RE: SUB19-002/SEP19-005 – Public Comments
Blueline Job No. 13-118

This letter is in response to public comments that were received during the public comment period for the 2825 West Mercer Way project. The comments (<https://mieplan.mercergov.org/public/SUB19-002/Public Comment>) were reviewed and grouped into categories to provide responses. A paraphrased summary of each public comment category is provided in a list below with our responses in bold.

SITE PLAN
2825 W MERCER WAY
PRELIMINARY PLAT
 PARCEL #2174502425
 CITY OF MERCER ISLAND WASHINGTON

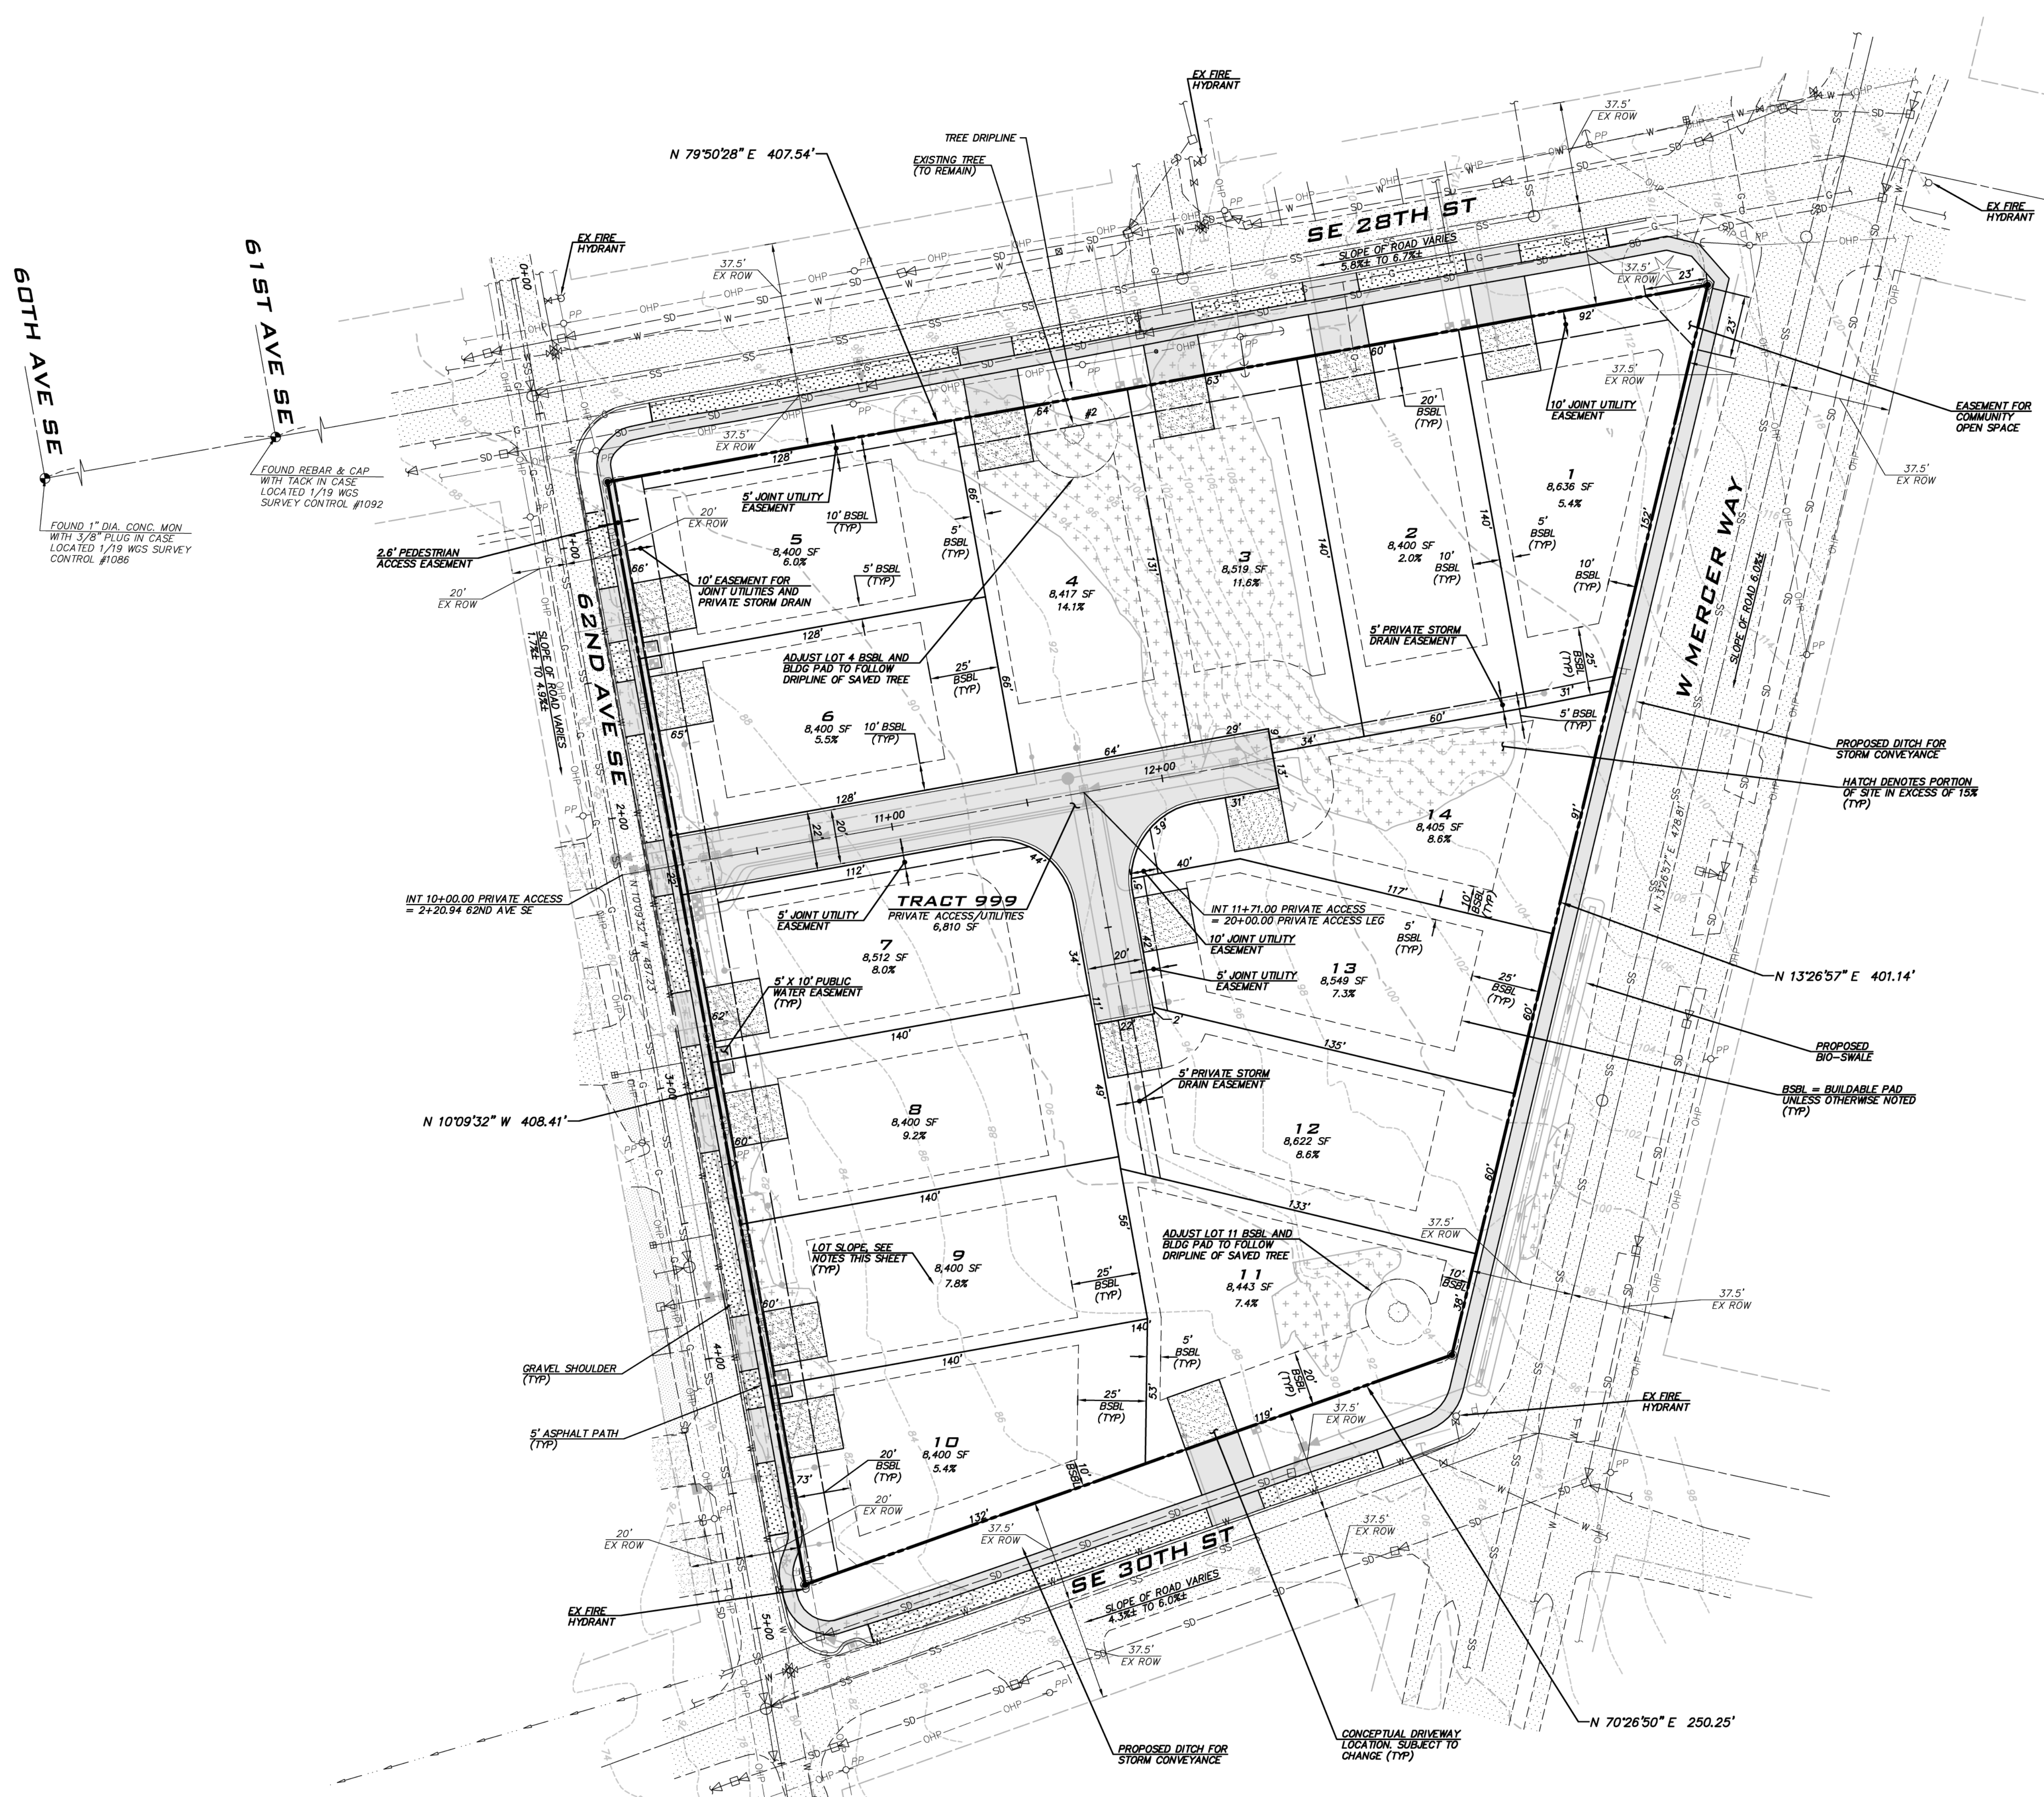
2. Traffic – public comments related to traffic covered topics involving increased traffic (in general and specifically on 62nd), need for additional parking, safety (sidewalk/path), access (width of road, vehicle turnaround).

The private access road has been relocated to take access off SE 28th St instead of 62nd Ave SE to reduce the number of trips via 62nd Ave SE.

Per MICC 19.02.020.G.2.b, each single-family dwelling with a gross floor area of less than 3,000 square feet shall have at least two parking spaces sufficient in size to park a passenger automobile; provided, at least one of the stalls shall be a covered stall. Each lot will have a 20-foot by 20-foot parking pad that can accommodate two parking spaces in addition to a two or

three-car garage. In the event that more than 3,000 square feet is proposed, additional parking for each dwelling will be provided.

A 5-foot-wide asphalt path is proposed around the perimeter of the site. An 8-foot-wide shoulder is located between the asphalt path and edge of travel way to provide a buffer between pedestrians and cars for safety.

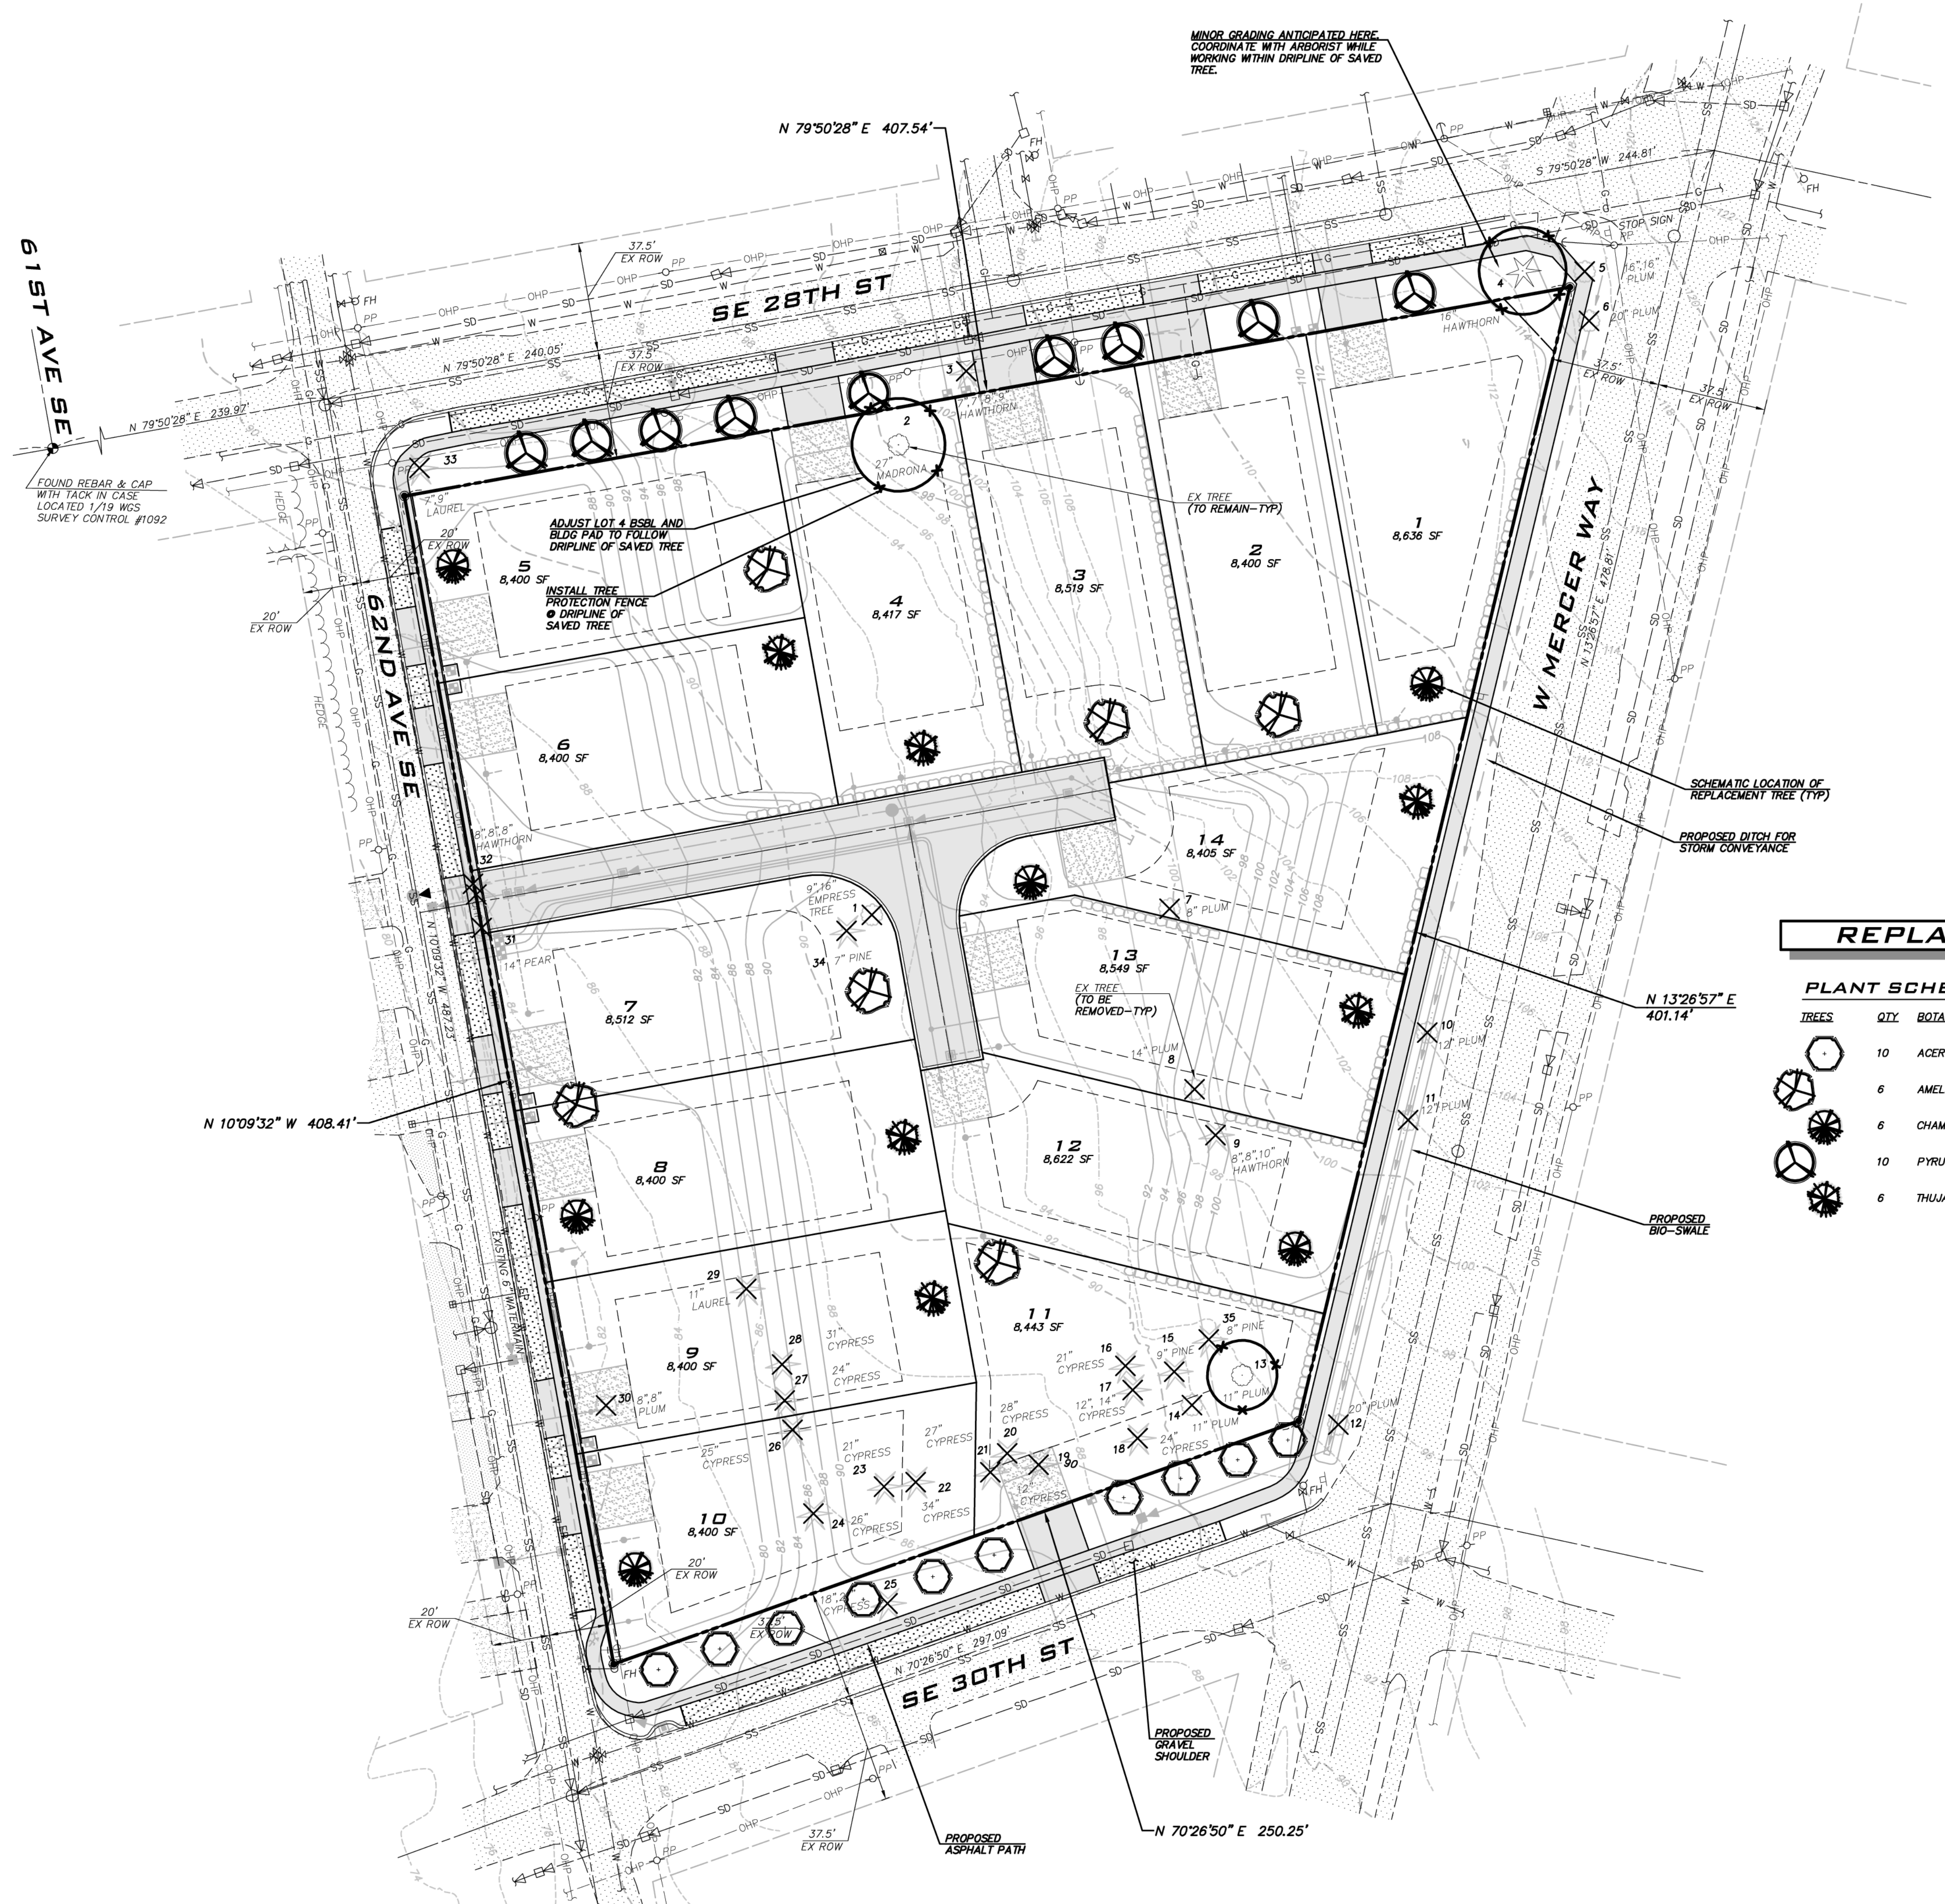
1. Trees – public comments related to trees covered preservation of specific trees on site (#2, 25), removal of exceptional/significant trees, tree replacement and proposed tree heights.

Trees #2, #4, #13 and #25 are being retained per the current tree retention plan.

Existing trees that are deemed nonviable by the project arborist or that are not regulated per the City's code (Leyland Cypress and Portugal Laurels, trees under 10") are not required to be retained. Although tree #2 is the only tree that is both viable and regulated, three additional existing trees are being retained. The project exceeds the minimum 30% tree retention as required per MICC 19.10.060.2.A.

Existing trees (includes nonviable, excludes nonregulated) will be replaced based on ratios outlined in MICC 19.10.070.A.

Per MICC 19.10.070.B.3, replacement trees shall be conifers at least six feet tall and or deciduous at least one-half inches in diameter at the base. We are not aware of City code that limits the tree height at maturity. We would be willing to plant a mix of trees with lower heights to preserve the views from neighbors.
